SUBJECT: **BRES2507-0007**
BUILDING RESIDENTIAL

Here are the results of all Inspections located at **47 EAGLE CREST CT:**

47 Eagle Crest Ct
Wilmington NC

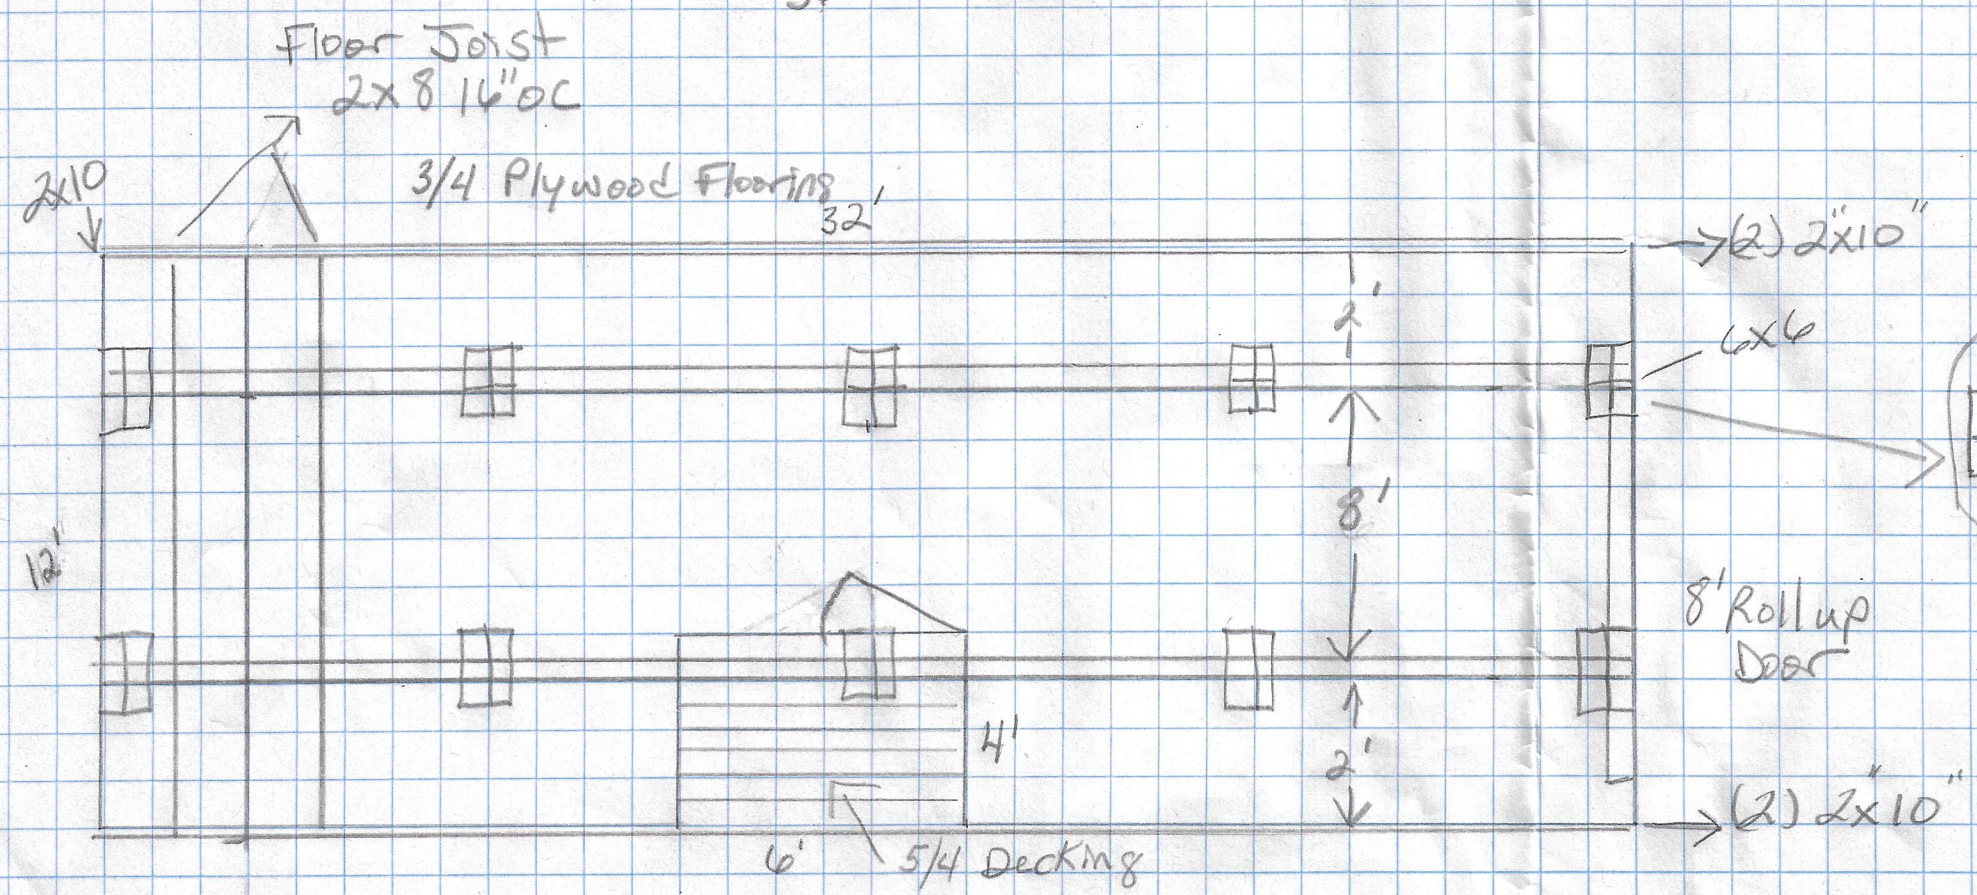
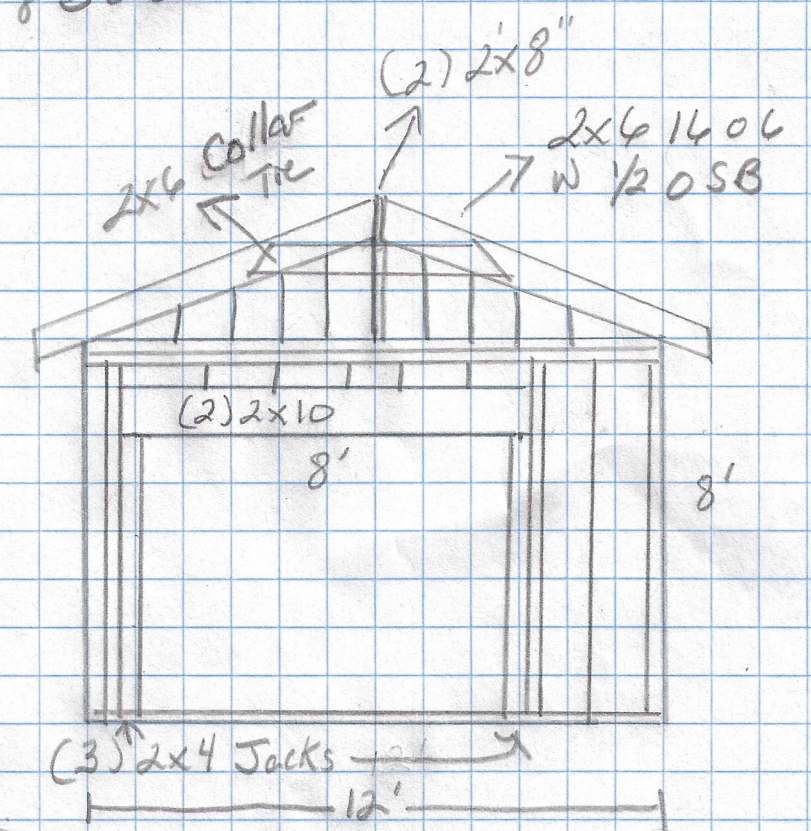
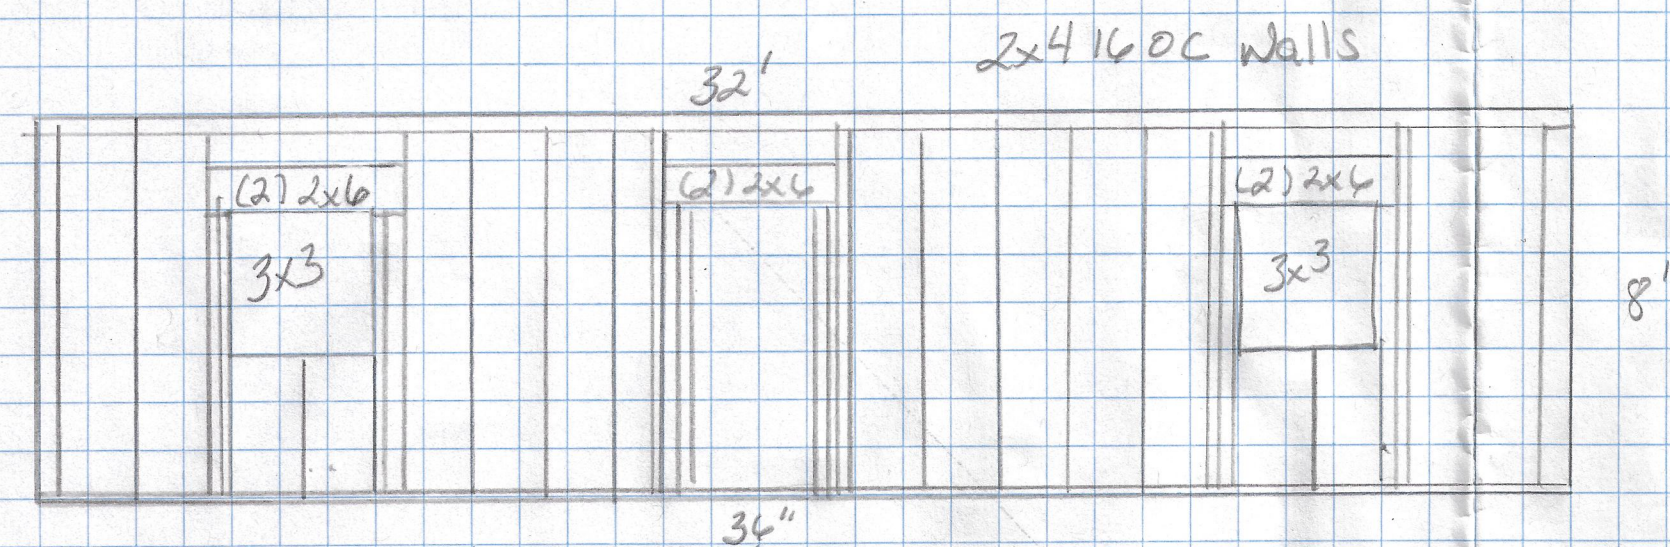
Inspection Type: FOOTING
Scheduled Date/Time: 7/22/2025
Completed Date/Time: 7/22/2025
Inspector: Steven Gazlay
Result: DISAPPROVED
Remarks:
Notes: Footings not deep enough. Bottom of footings must be 12" minimum below grade.
